660 Congress St - Permit #2017-00970

I am trying to complete my Zoning review of the permit and I have a couple of questions.

DWG. CONTENTS:
1ST FLOOR PLAN

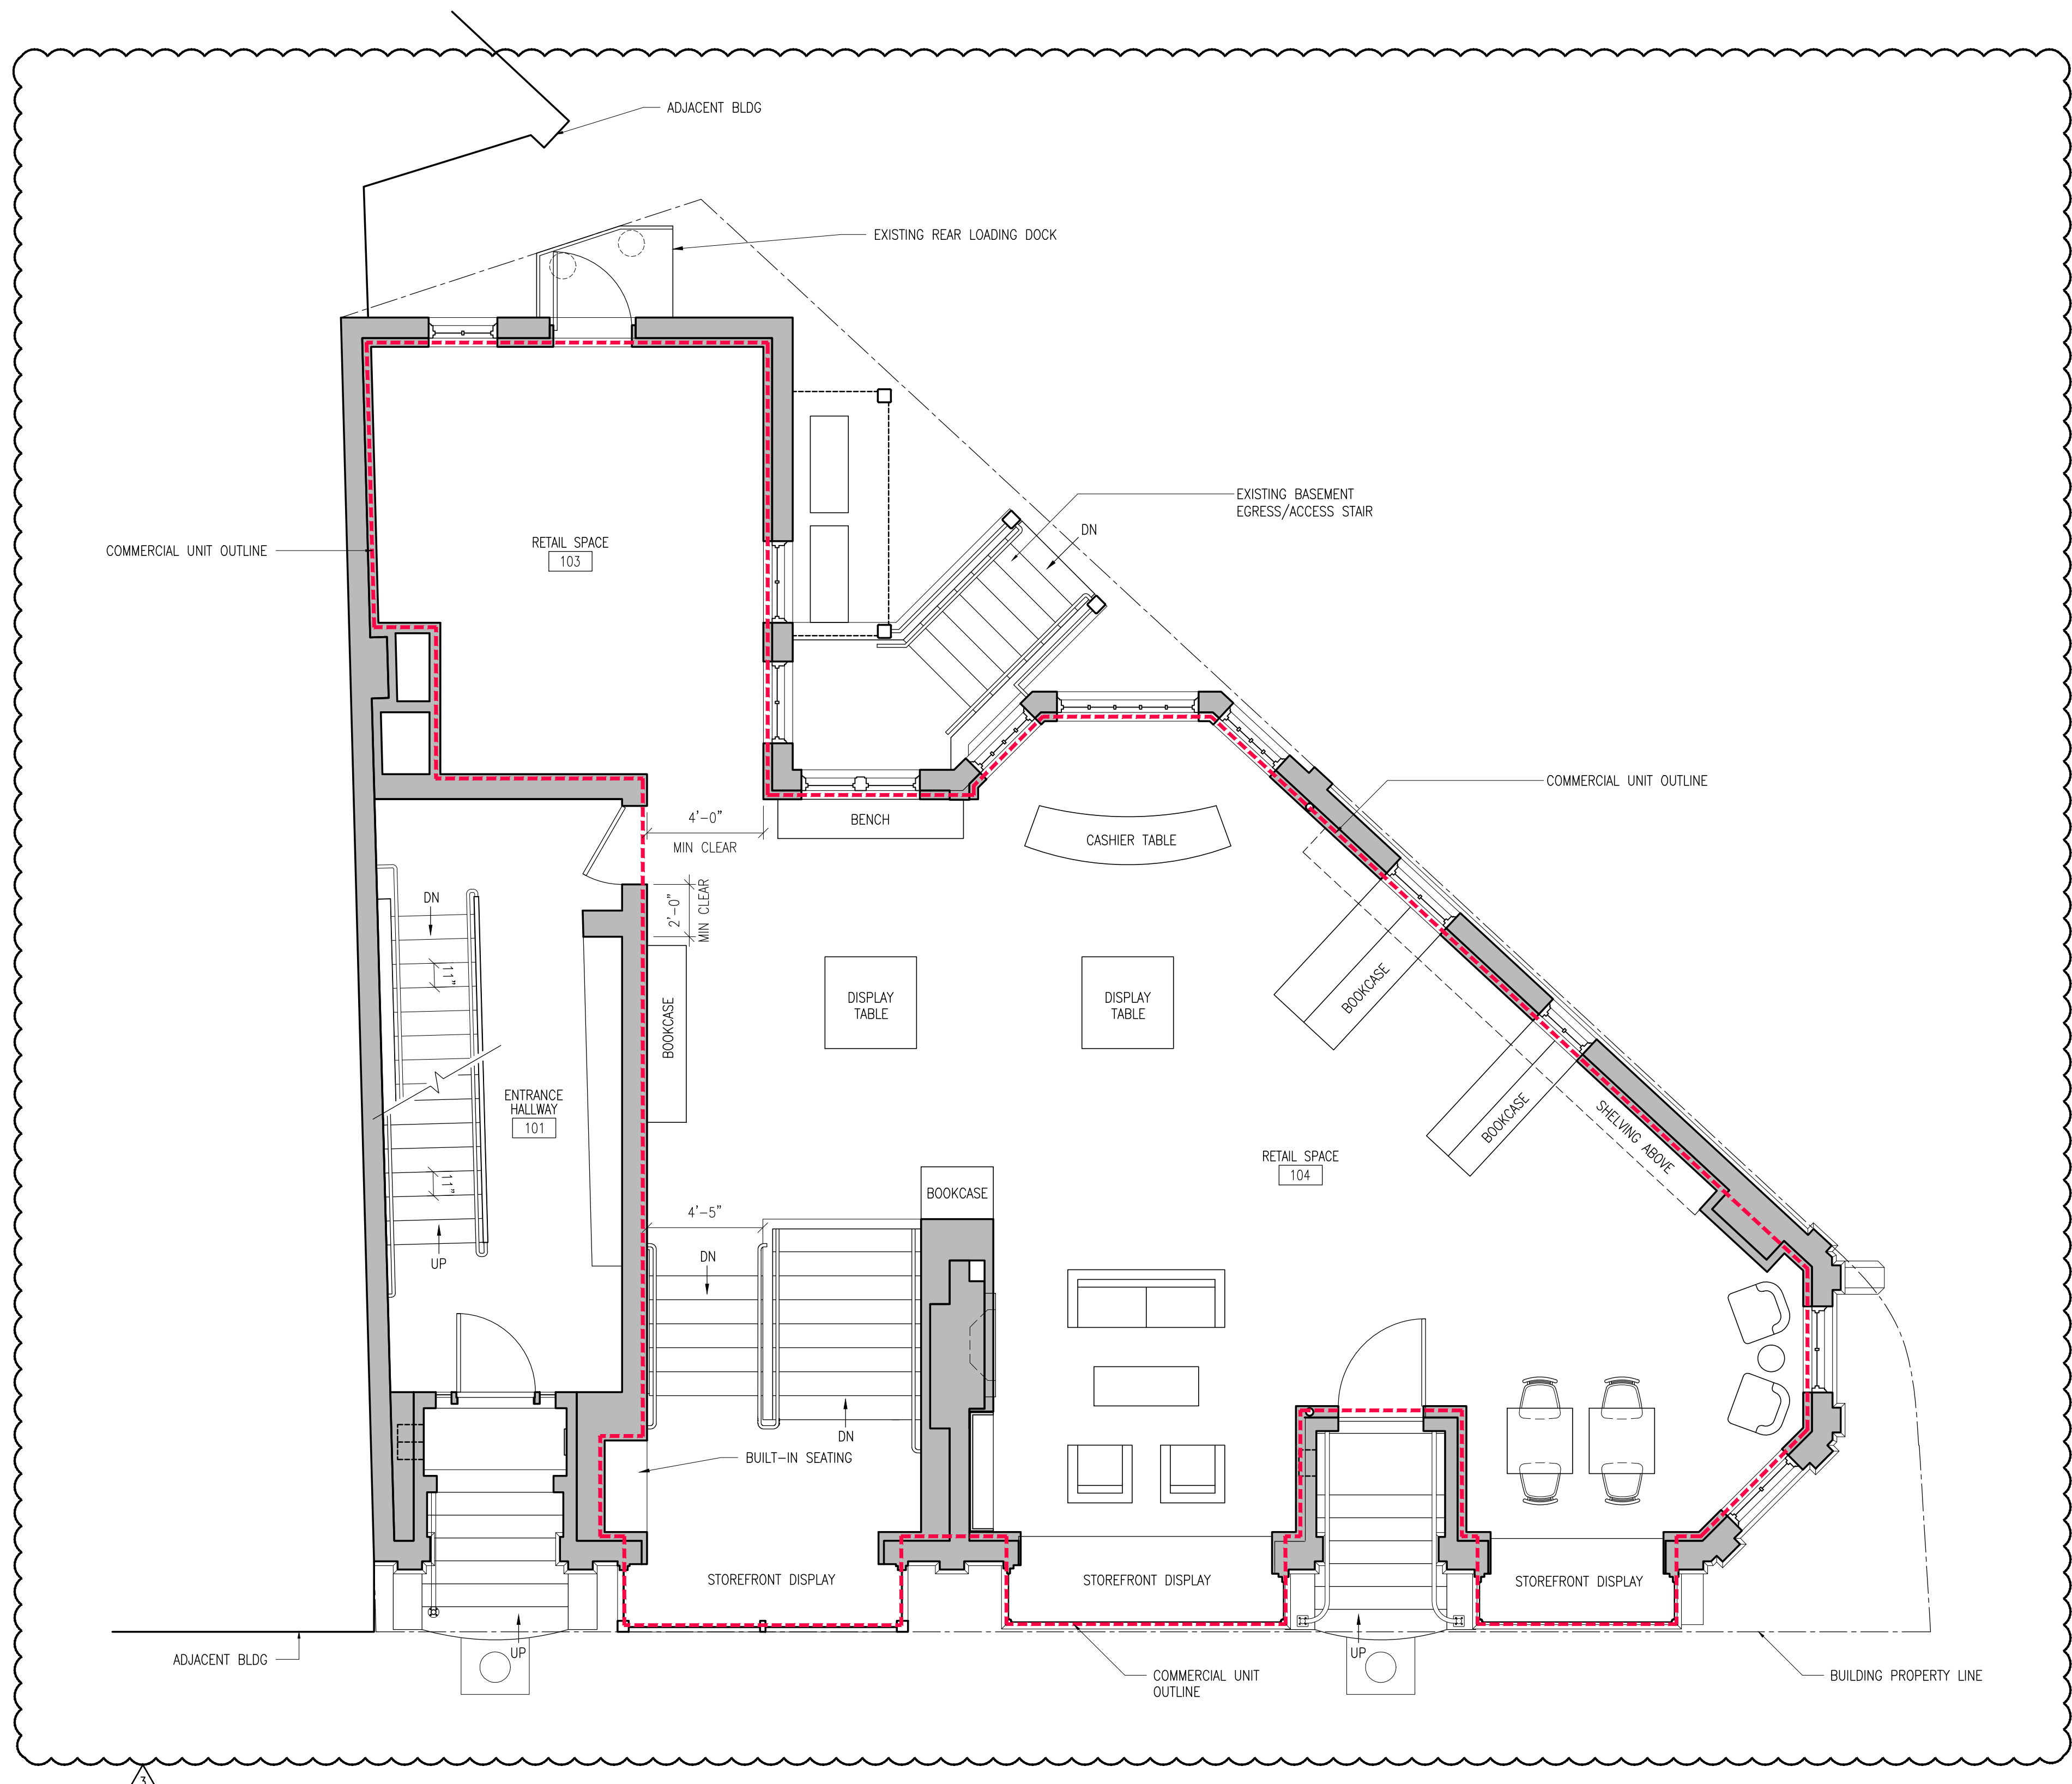
The reason that I ask is the Congress Street facade is located in the PAD (Pedestrian Activities District) Overlay zone. Section 14-217(b)(1)(a) outlines the specific uses that are allowed and a specific area of the first floor that must meet the permitted PAD use. I just need to confirm that the retail space will meet this. I have attached the section.

Retail Frontage: At least 75% of the street level (1st Floor) frontage along Congress Street will be retail display space

Retail Use Depth: Minimum of 20 feet (as allowed by the roughly triangular footprint of the building)
